25 March 2014

**Re: Proposed Section 96 (1A) Modification to SSD 5307\_2012 and SSD 5729\_2012  
Bega Valley Health Services Redevelopment**

Overall Elevations
DRAWING NUMBER
BWN-ARC-C1-XX02
ISSUE
4

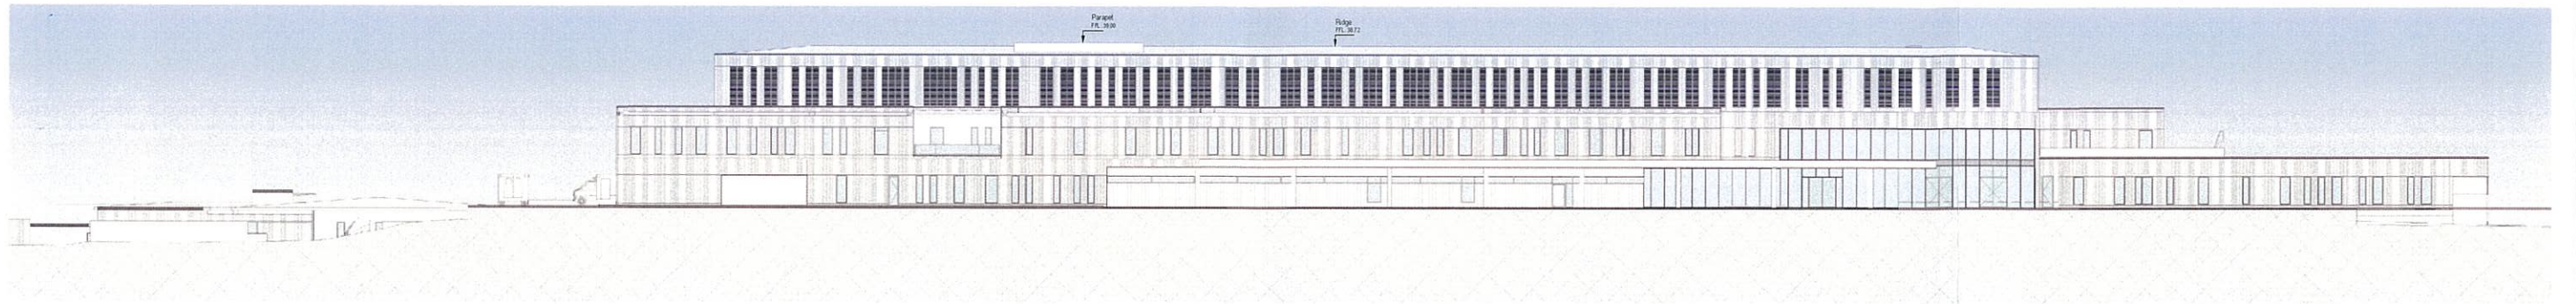
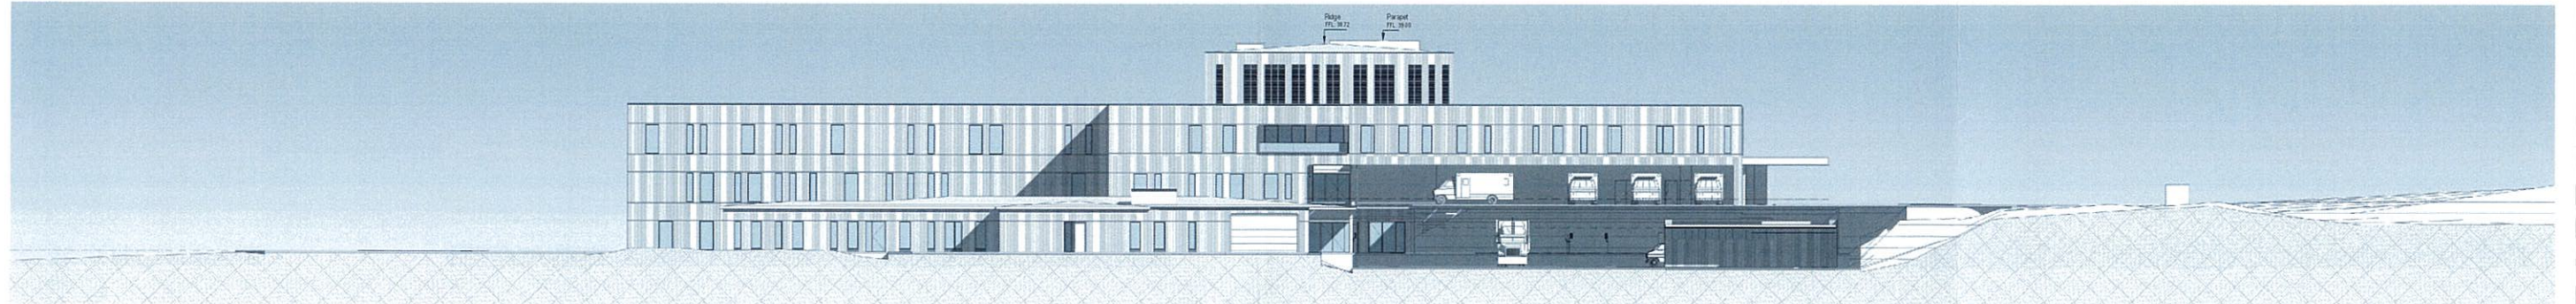
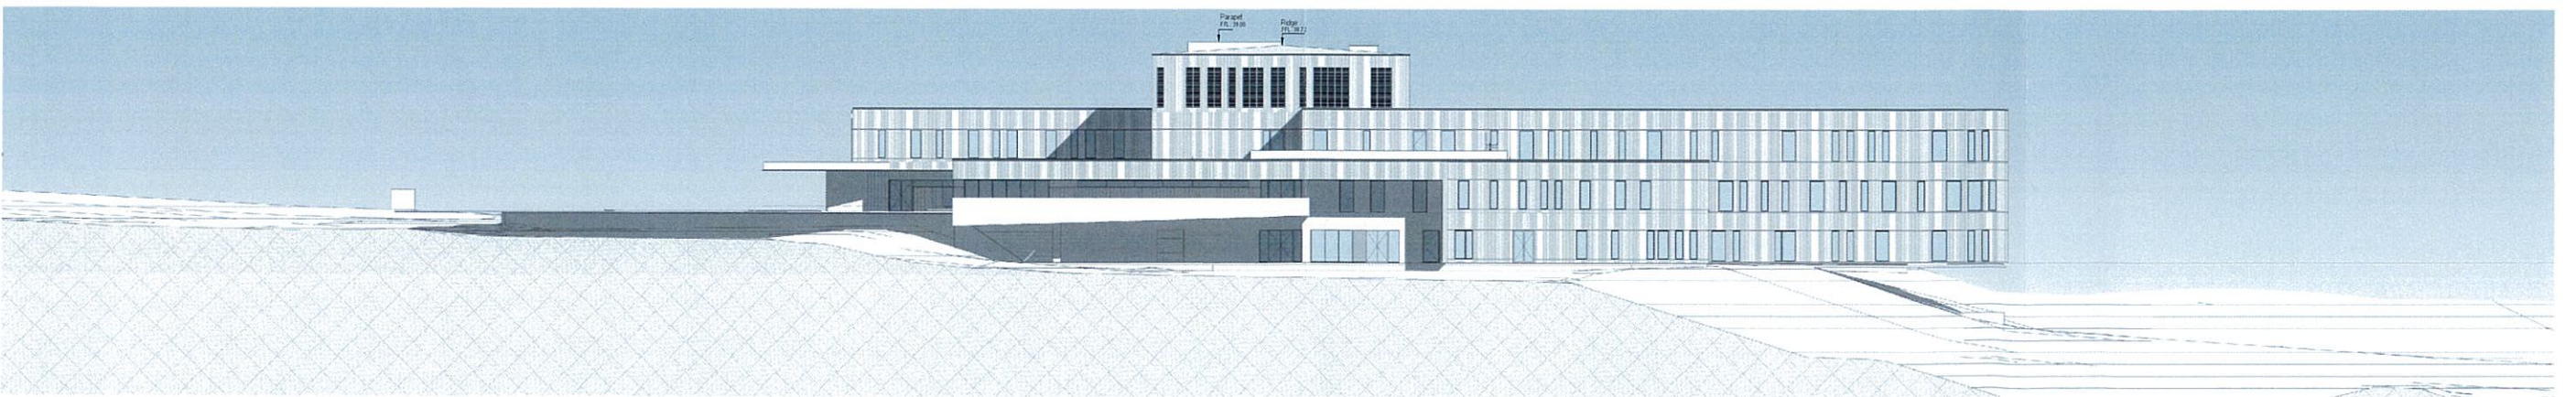
The approved design includes a pitched roof constructed of metal sheeting in specific locations. The revised design replaces the pitched roof with a flat style roof. In addition the height of the building is increased by 200mm from RL 38.80 at the ridgeline to RL39.00 to allow for greater floor to ceiling heights. The amendment will have no impact on the external environment and is considered to be a very minor change (refer to Attachment A).

The pitched roof, originally added to create interest in the roof line, has been determined to add little to the exterior look of the building from the view point of people using the building and cannot be noticed from a distant view. The flat roof provides a more functional outcome without additional cost and without any negative visual impacts on users, visitors or people viewing the building from the street and Tathra Road. The proposed amendments are still consistent with the original design statement.

<i>Issue</i>	<i>Action</i>
Condition A2	Amend date of Drawing PA-0X08 dated 9/7/2013 to BVN-ARC-C1-XX02 Issue 4 dated 4/2/14 as per the attached revised drawing.
Condition B1 a)	Amend "The maximum height of the building is RL39.00AHD"

1
SK_108
1 : 500
PLANNING ELEVATION EAST

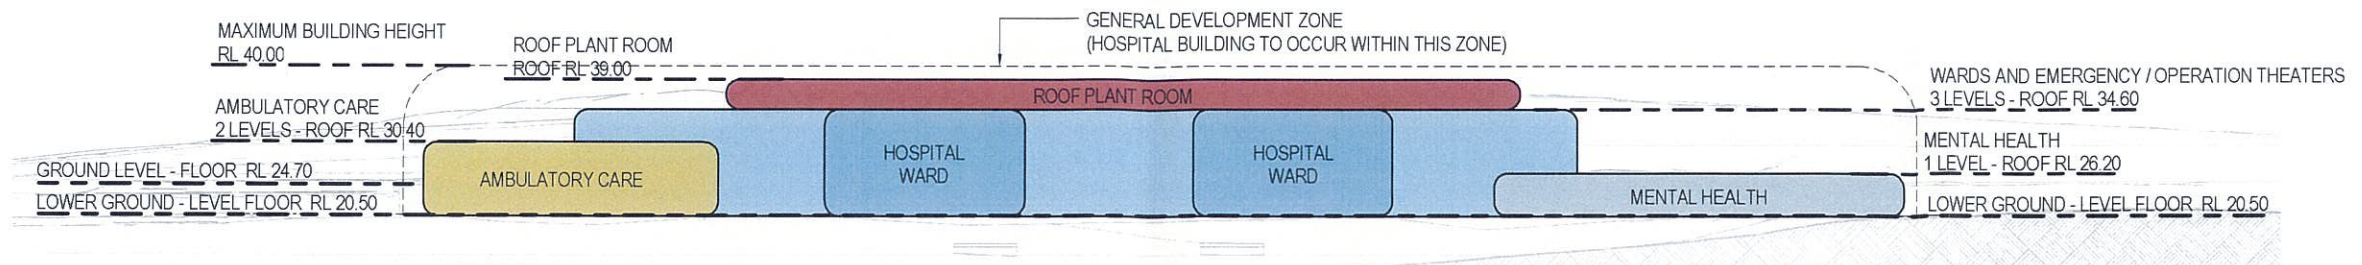
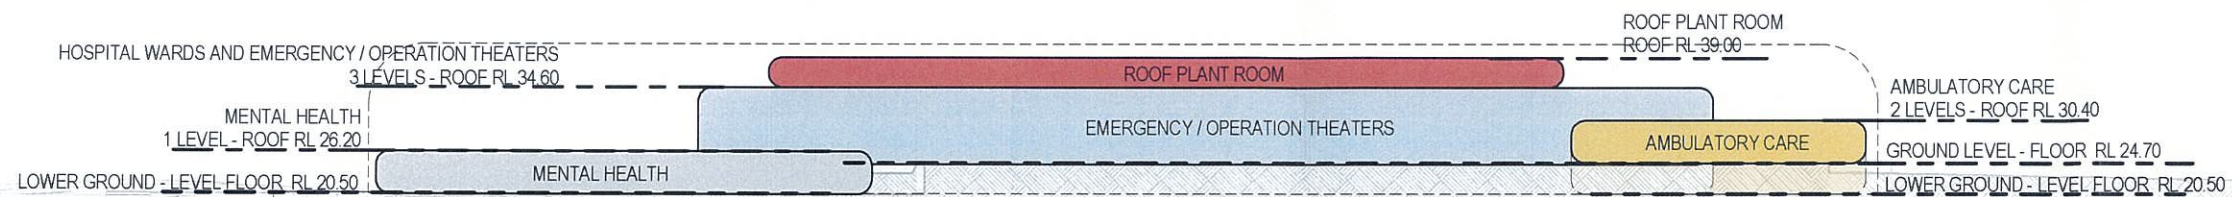
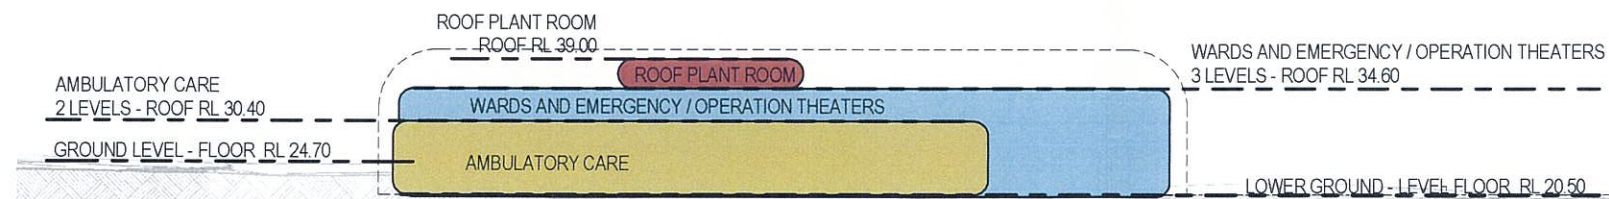
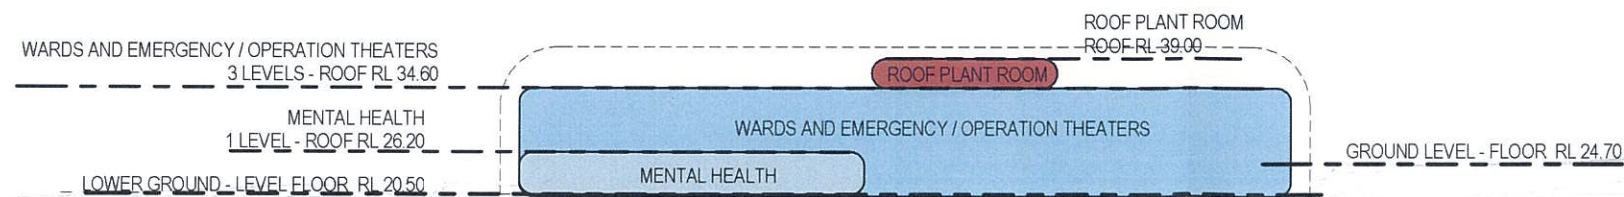
<i>Issue</i>	<i>Action</i>
Condition A4	Amend date of Drawing SK_107 and SK_08 dated 8.10.12 to SK_107 and SK_108 dated 18.3.14 as per the attached revised drawing.
Condition A8.	Delete
Condition A17	Delete
